Attachment A – Response to Agency Submissions (SSD 7275) 80-88 Regent St, Redfern

The following table includes a response to the full text of submissions provided by or on behalf of State and local government agencies. For completeness, the full text of each submission is provided in the left-hand column, accompanied by the proponent's corresponding response in the right-hand column. The proponent's responses have been informed by input by the expert consultant team and should be read in conjunction with the publicly exhibited Environmental Impact Statement and accompanying technical reports, as well as the Response to Submissions Cover Letter to which this document is appended.

8.8m MRV Truck Turning Paths

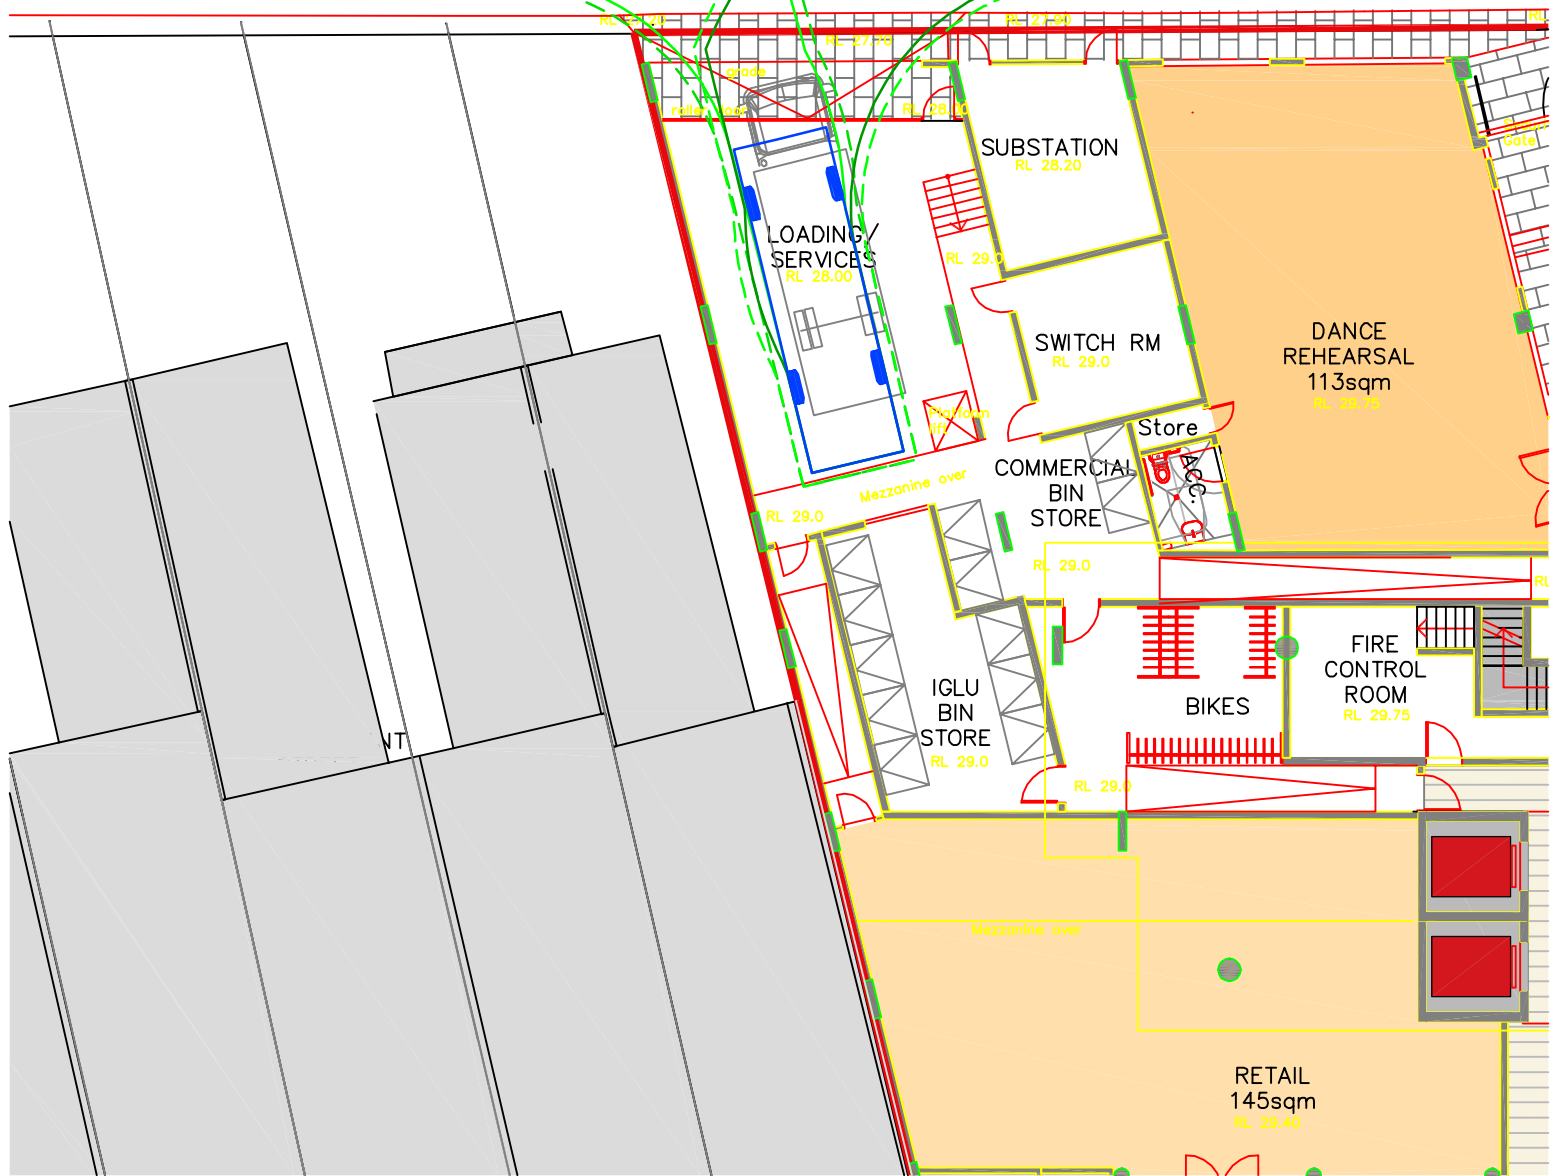
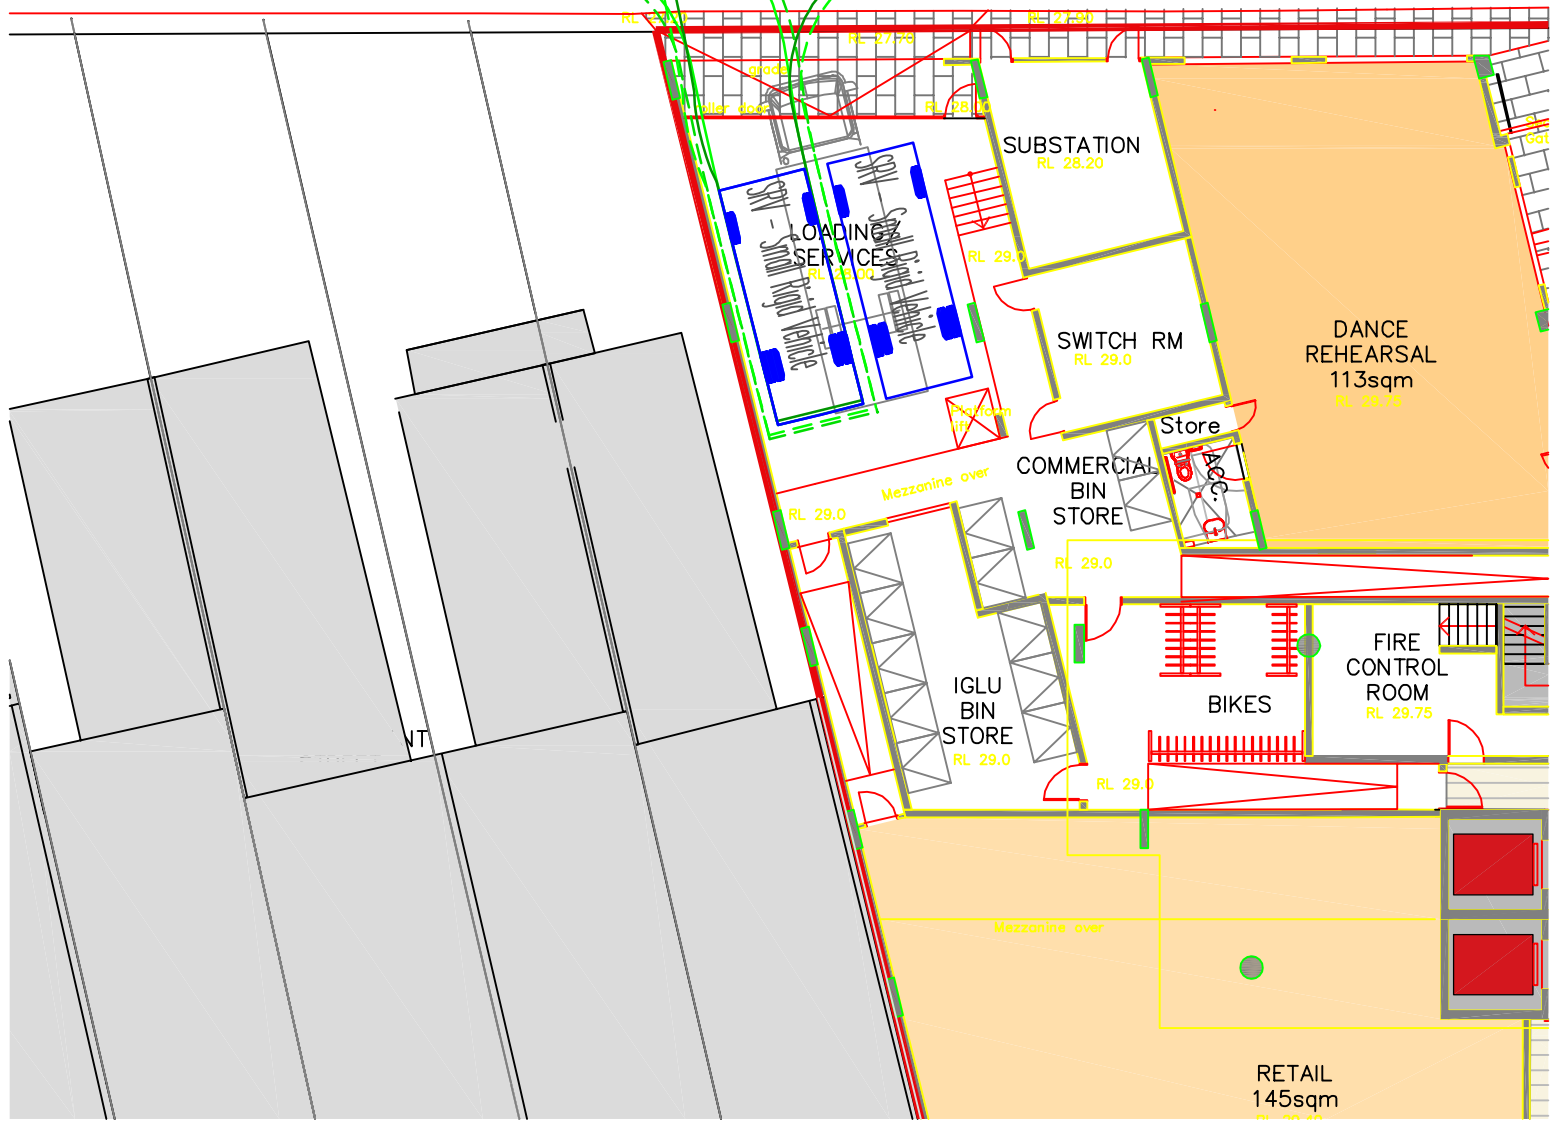
RMS 1e	<ul style="list-style-type: none"> The swept path of the longest vehicle (to service the site) entering and exiting the subject site, as well as manoeuvrability through the site, shall be in accordance with AUSTROADS. In this regard, a plan should be submitted to Council for approval, which shows that the proposed development complies with this requirement. 	The proposal does not include a vehicle access point. The proposal will utilise the existing loading dock contained within the adjoining Iglu development. Swept path diagrams provided during the assessment of the existing Iglu building under SSD 14_6724 are available at Attachment K .
RMS 1f	<ul style="list-style-type: none"> Vegetation and proposed landscaping/fencing must not hinder driver sightlines to/from the driveway to road users on Gibbons Street 	The proposal will not inhibit sight lines for road users on Gibbons Street.

Item Raised		Proponent's Response
		William Lane. As such, the swept paths prepared for the existing Iglu 1 building have been provided at Attachment K which confirm that suitable vehicle access can be provided to continue to service the site.
DPE 15a	Site amalgamation Provide additional information regarding the lot consolidation and timing.	Iglu propose to consolidate the lots prior to the issue of the Occupation Certificate. This can be conditioned as a requirement to be satisfied prior to the issue of an Occupation Certificate.
DPE 15b	Demonstrate how the development could still function as two separate lots.	It is not intended for the development to function as two separate lots.
DPE 15c	Provide detail as to how development consent for the alterations and additions of the existing site will be managed.	<p>In general, the following works are required to be undertaken:</p> <ul style="list-style-type: none"> • The precast walls between the courtyards will be removed and the courtyard design amended to reflect one larger external terrace; • A new opening will be created in the walls at the southern end of the existing Iglu building lounge area; • New doorways will be cut into the precast wall panel in the southern wall of the loading dock to allow access to the shared loading dock • Services connection from the existing Iglu building to the proposed development including electrical mains, sprinkler and hydrant mains, water and gas mains, as required. <p>These changes will be sought as a separate Development Application/ Section 4.55 modification or will be subject to a separate CDC, as appropriate.</p>

**Figure 2 Visual privacy measures**

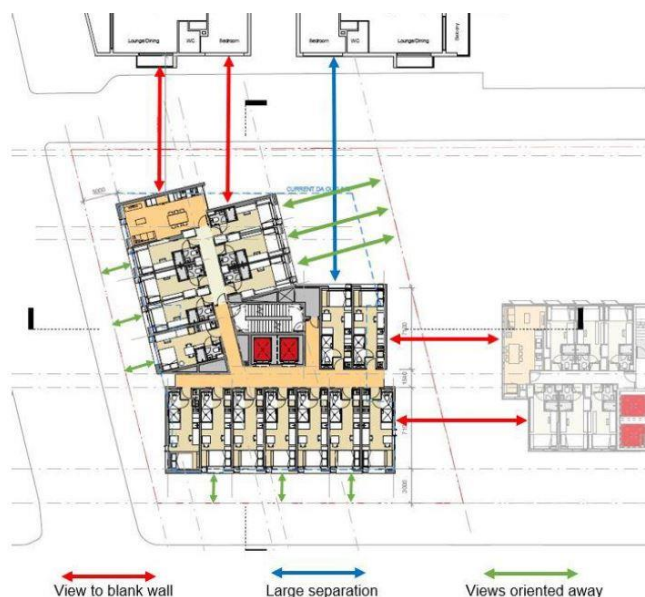
Item Raised		Proponent's Response
GA 4a	<p>Residential amenity</p> <p>We support the operable glazing solution to enable noise control and natural ventilation to units provided it meets the relevant City of Sydney acoustic control guidelines. Further, we recommend the following to improve residential amenity:</p> <ul style="list-style-type: none"> Review and revise unit layouts to ensure the maximum number of units are provided with appropriate solar access where possible. 	<p>The proposal was subject to comprehensive testing to develop the optimal layout in terms of floor plate efficiency, internal amenity and privacy to surrounding residents. This is supported by Figure 2 of the cover letter. Within the proposed building, a typical floor plate contains seven studio rooms oriented to the east to maximise access to morning sun and the sweeping eastern district views. Units are largely oriented away from the north, as this aspect is defined by the existing Iglu 1 building and other residential towers to the north-east, and as a consequence the northern façade is provided with limited glazing to maintain appropriate levels of privacy between the two Iglu buildings. As such, the proposed floor layouts are considered optimal.</p>

GA 4b	<ul style="list-style-type: none"> Ensure sections of full-height glazing to units are accompanied by integrated features to provide occupants with the ability to control the visual privacy of their units from exposure to the street and minimise solar heat gain. 	<p>Each room is provided with an operable full height blind to assist in managing visual privacy and solar heat gain.</p>
GA 5a	<p>Bike Parking</p> <p>While we note improved access to street level bicycle parking has been provided in the revised design, there was insufficient information to substantiate the quantity of bicycle parking for the proposal and in relation to the adjacent Iglu student accommodation building. We recommend this information is provided in the Response to Submissions.</p>	<p>Refer to Section 6.4.1 of the EIS and the Traffic Impact Assessment prepared by Varga. It is noted that additional end of trip facilities have been included on the ground floor to service retail and commercial tenants.</p>

Level 01

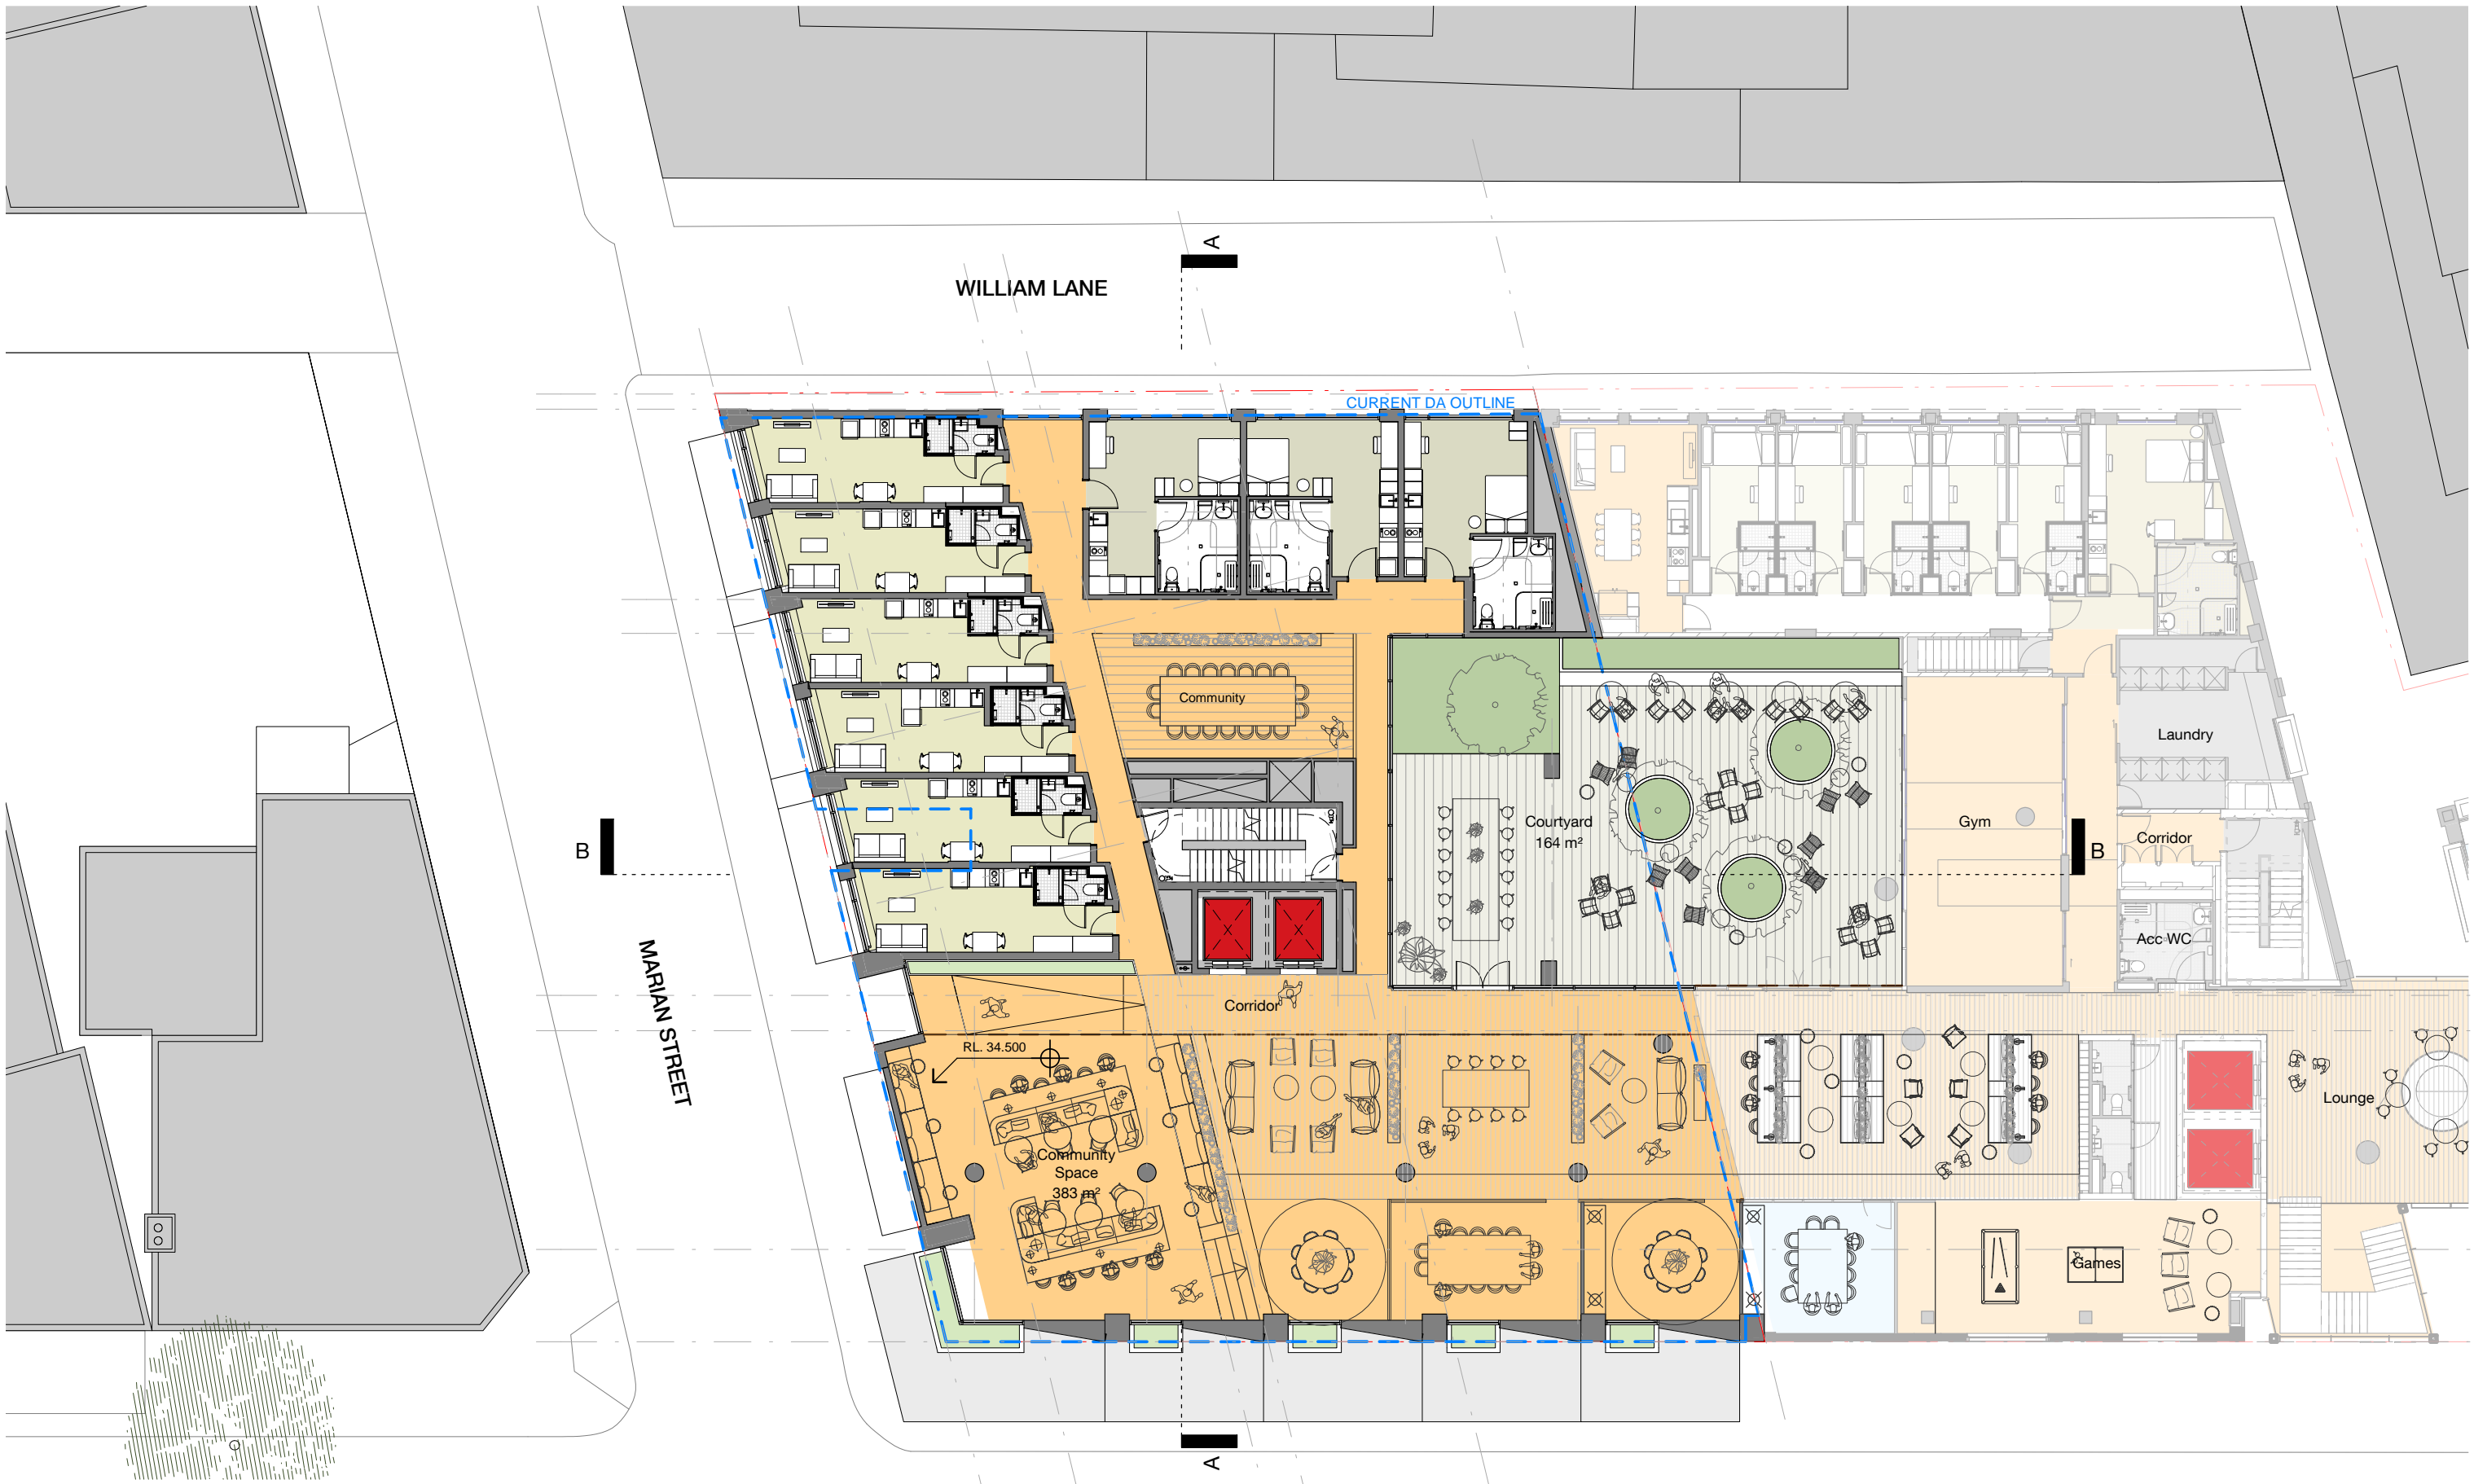
GA 2a	Courtyard We acknowledge the design team's rationale to maintain the height of the courtyard undercroft, however, recommend light-coloured materials and finishes are used to clad the soffit, to maximise reflected natural light in this area.	Light-coloured materials and finishes have been employed to clad the soffit, maximising reflected natural light in this area. Refer to the supplementary design report at Attachment B .
GA 3a	Architecture We support the design strategies to modulate the building façades, evident in the use of colour, configuration of glazing, and surface relief visible along Botany Road. However, we recommend the extended application of these strategies to the blank sections of north and west facade, in particular along William Lane, to improve the visual appearance of the building as perceived from neighbouring residential buildings and the public domain. We recommend considering further integration of surface relief, additional glazing, infill panels of different materials or colours. Should the proposal demonstrate a satisfactory response to these recommendations, we would support the encroachment of the building mass over the current DA alignment to William Lane.	In response to the GANSW's advice, the western façade has undergone minor design development as detailed within the supplementary design report at Attachment B . Further discussion is provided at Section 1.2 of the cover letter.

CoS 5b	<ul style="list-style-type: none"> The testing does not include a point within the covered section of the Level 1 courtyard, where wind impacts may differ / increase due to the overhang immediately below the sheer wall of the tower. 	<p>Windtech has located test points in the most critical locations. The location of points 11 and 12 are located in such a way they capture the critical downwashed winds from the tower above. The area under the courtyard is not as critical as the other two locations. Windtech conclude that the flow stagnates in this region under the tower due to the nature of the building form.</p>
CoS 5c	<ul style="list-style-type: none"> The 'fail' result at location 13 is justified through the recommended treatment of densely foliating evergreen trees planted in a particular format. This treatment is not demonstrated in the proposed design. 	<p>The design has been amended accordingly and the cover letter prepared by Windtech at Attachment P confirms that the proposal now satisfies their recommendations.</p>

<p>CoS 14f</p> <p>It is recommended that:</p> <ul style="list-style-type: none"> the design of the Level 1 communal open space be reviewed to achieve a minimum 50% soft landscaped areas, additional facilities and include wind mitigation measures for comfort 	<p>The Level 1 communal courtyard has been designed in response to the developments function as student accommodation and the required amenity for its occupants, primarily active external space. Furthermore, half the courtyard is undercroft space and bound by 17 story high buildings which don't facilitate for expansive garden areas. Fundamentally, the site conditions do not support, nor it is not appropriate to the function of the building to increase garden areas.</p> <p>The design of the rooftop terrace has been carefully considered by 360. The proposal responds to the wind mitigation recommendations provided by Windtech through the incorporation of densely foliating trees within the integrated courtyard (refer to Attachment P).</p>
